Memorandum

Re: Mixed Use Development at 321 Commercial Street; Level III Site Plan/Subdivision, J B Brown & Sons Applicant.

Project #: 2012-615 **CBL:** 40-E-3

Meeting Date: November 13, 2012

LANDSCAPING PLAN

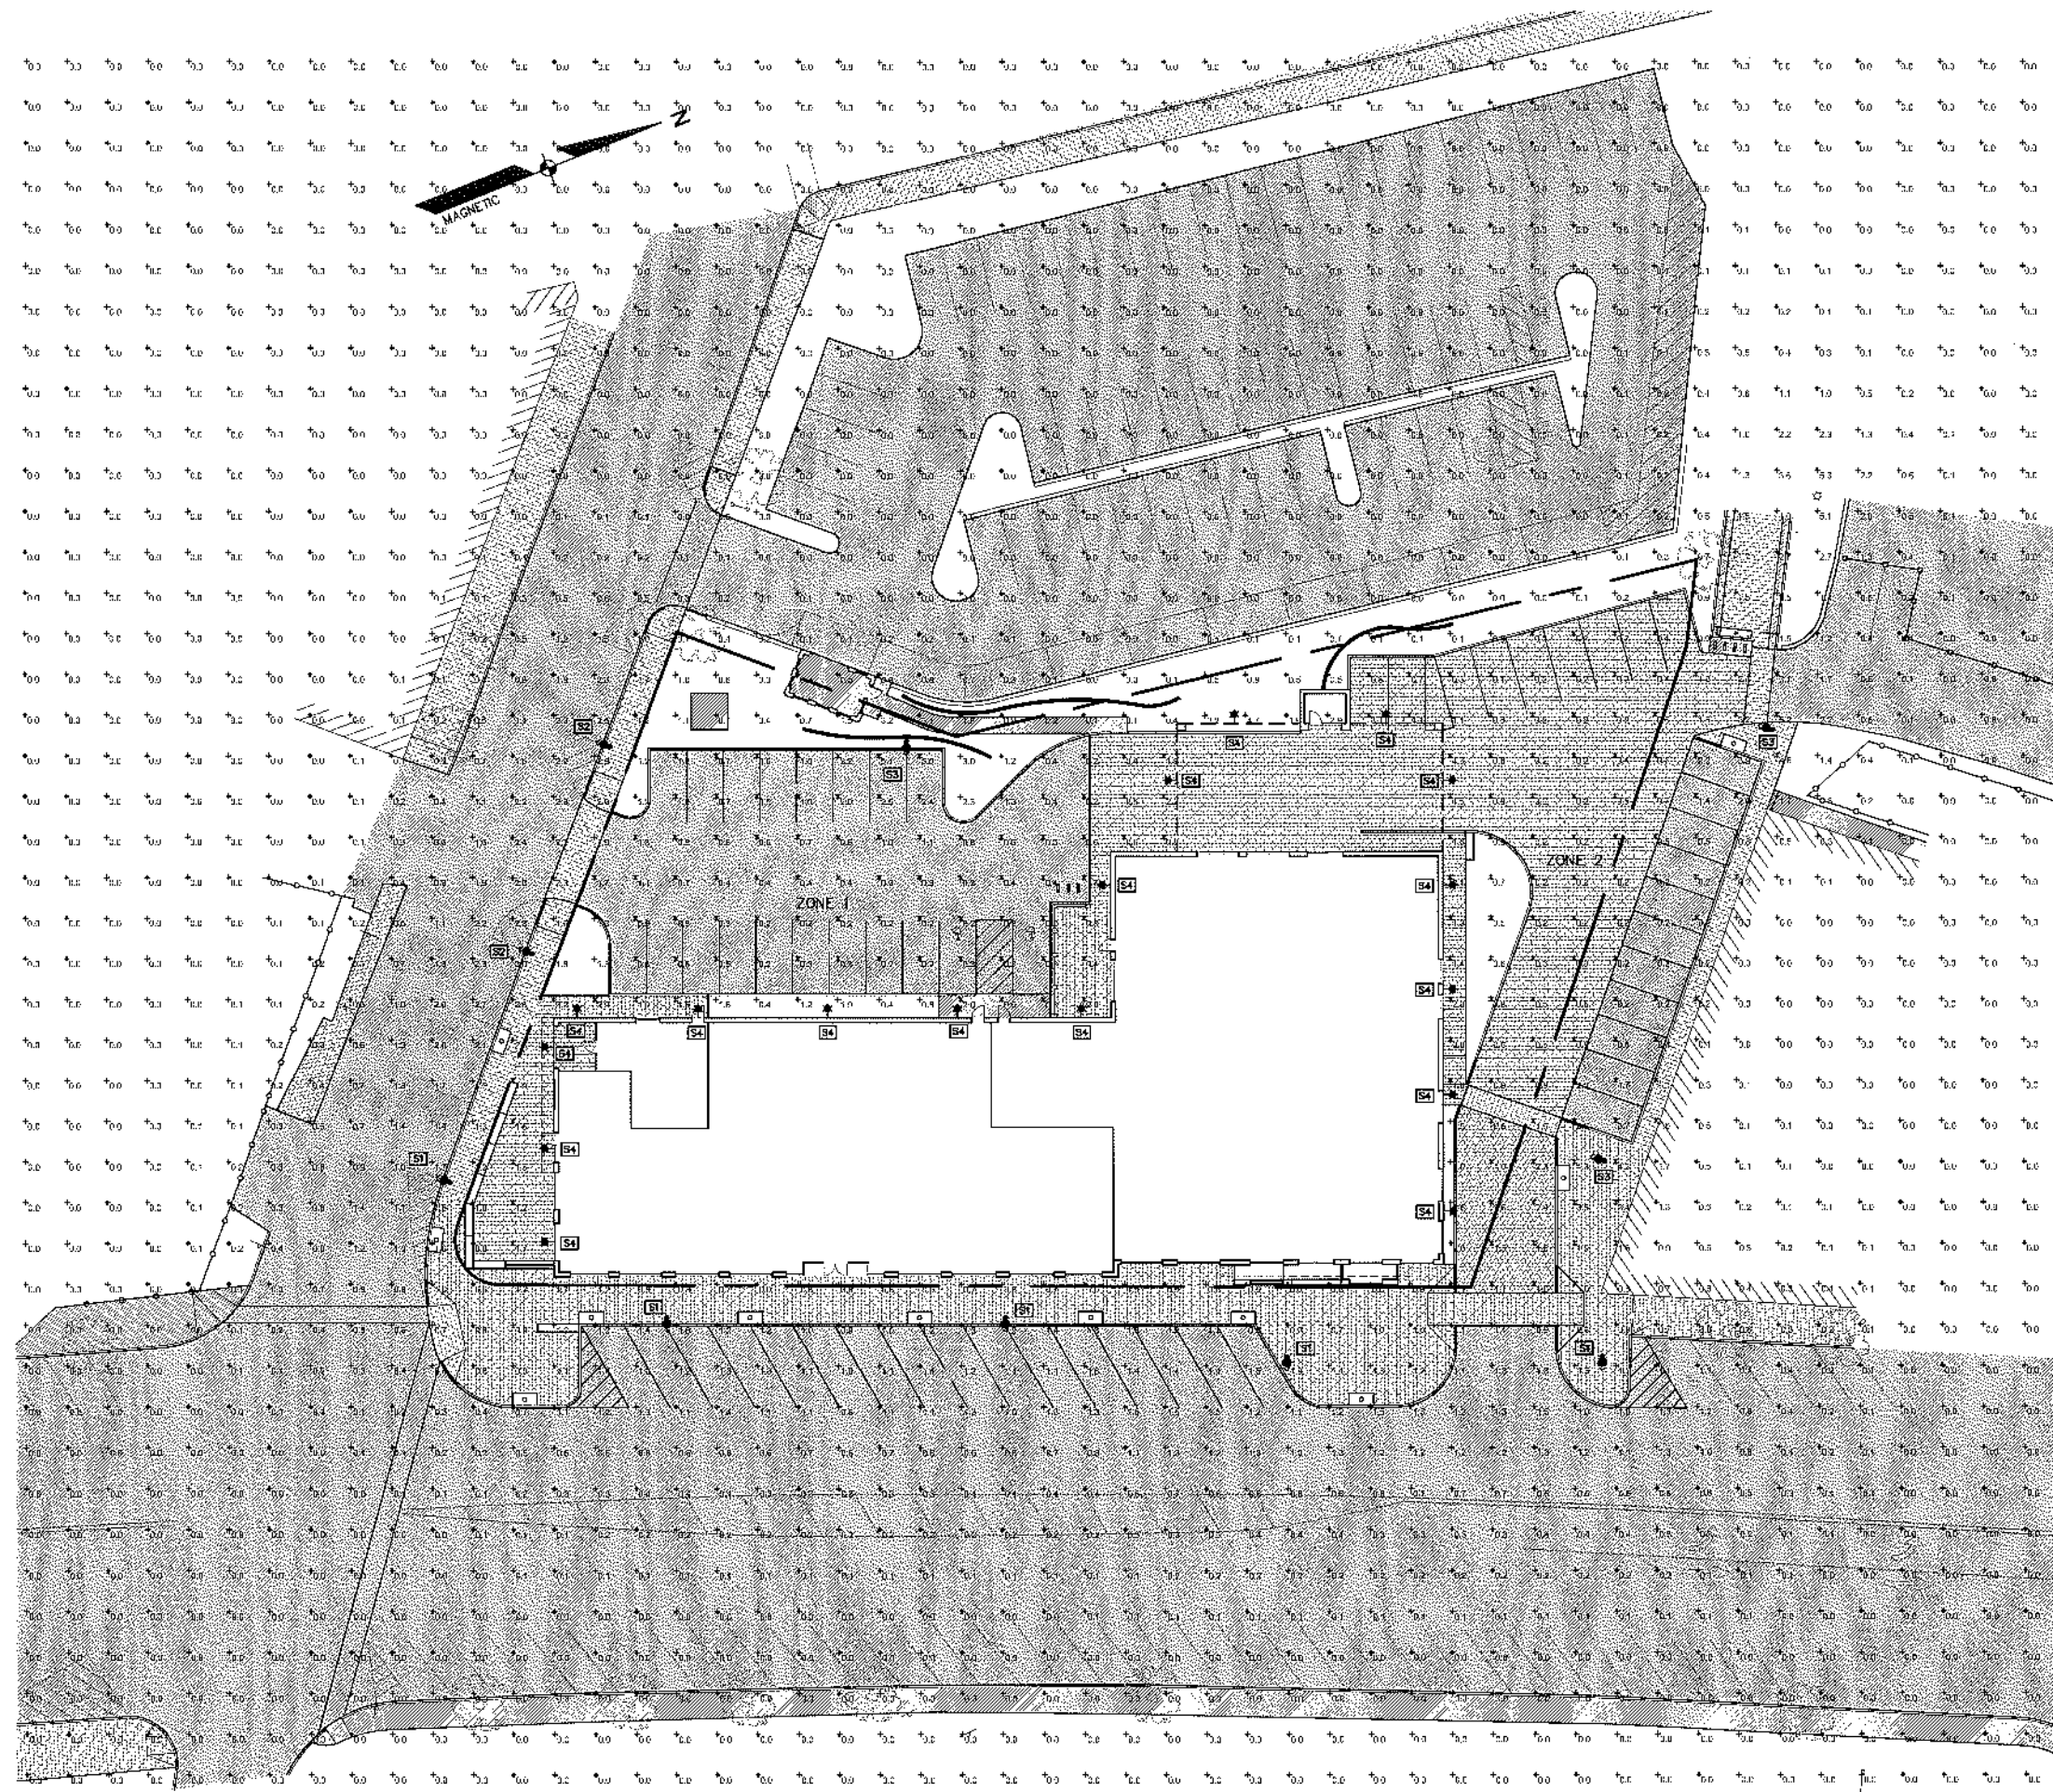
- *The landscape plan includes 'street-tree' planting along Commercial Street. The proposed trees, Zelkova and Honeylocust are planted in rectangular tree wells with tree grates. Tree grates are spaced in between the diagonal parking spaces which should reduce the vehicle impact. While we strive to plant all trees when possible in raised planters to protect them from compaction and deicing salts this location might be best treated with flush rectangular tree-wells with Neenah tree grates.*

- *Additional planting spaces - there appears to be opportunity to use the two parking lot bump-outs along the right or easterly side of the building to create a larger planting space for tree(s) / landscape planting. Currently the plan shows a tree within a tree grate near the parking lot. A similar treatment proposed in item (a) for Commercial Street and the area near Foundry Lane that could be used to expand the landscape & tree space. Providing larger soil volume for the trees help ensure their survival along with protecting them from winter deicing salt provided by the raised granite planter.*

- *Thus a Recommendation / condition would be to create an ornamental planter(s) in the new Commercial Street bump-out, the bricked in space along Foundry Lane and perhaps a space in the parking lot near Maple Street that would serve also as a storm-water planter. These spaces could be planted with shade tree / ornamental trees, woody and herbaceous planting. These planter(s) could be created by using a second granite curb within the bump-out similar to one used at 494 Congress Street and or the detail sheets in the storm-water information attachment.*
